CITY & COUNTY OF SWANSEA

Sixth Deadline Comments

Abergelli Power Project

Deadline 6 Submission

Illustrative Elevation of Road Structure Over Utilities

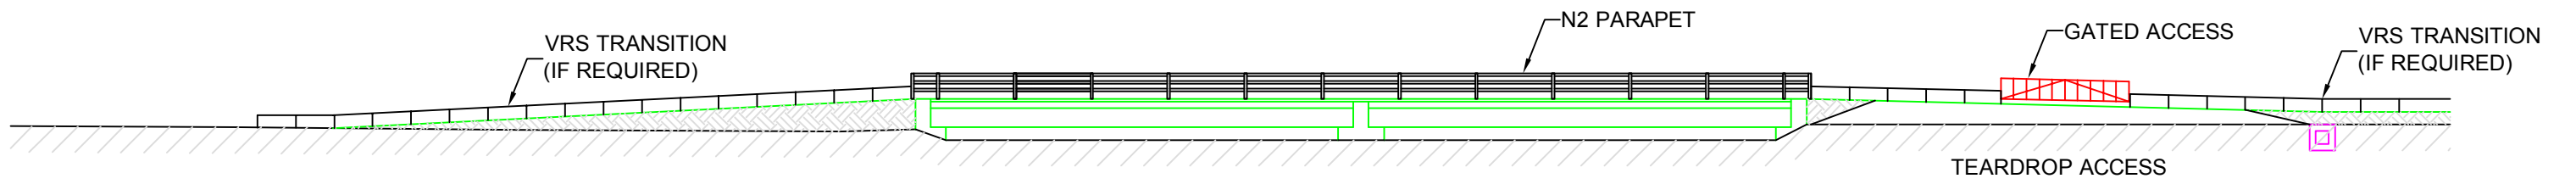
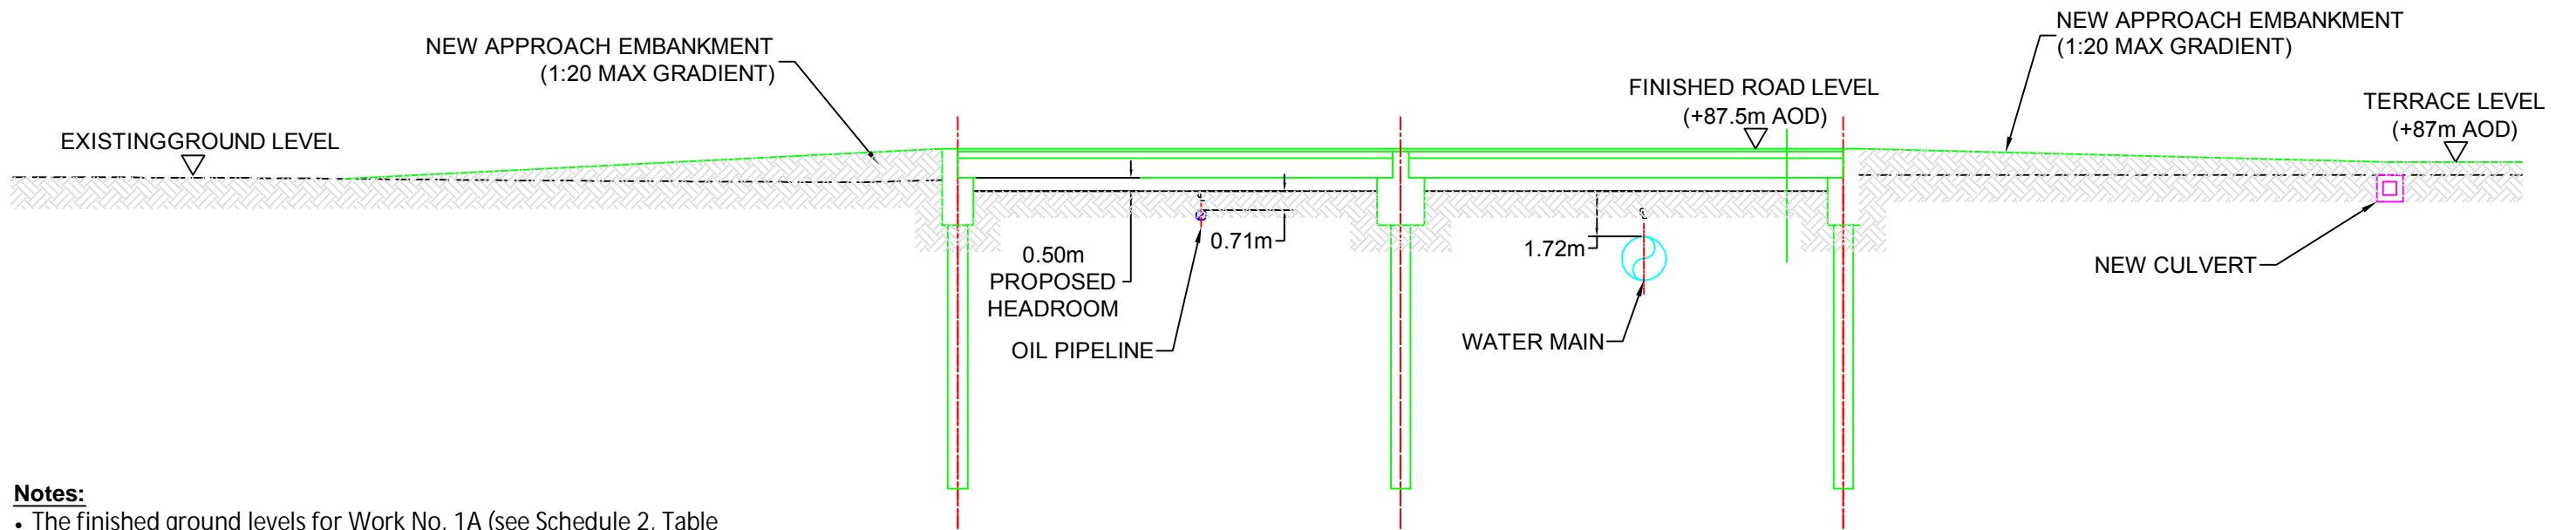
Grid lines have been added to the table to clarify that the safety barrier and crossing structure are two separate items. The applicant has indicated that the safety structure is not included within the maximum height of the crossing structure which is accepted.
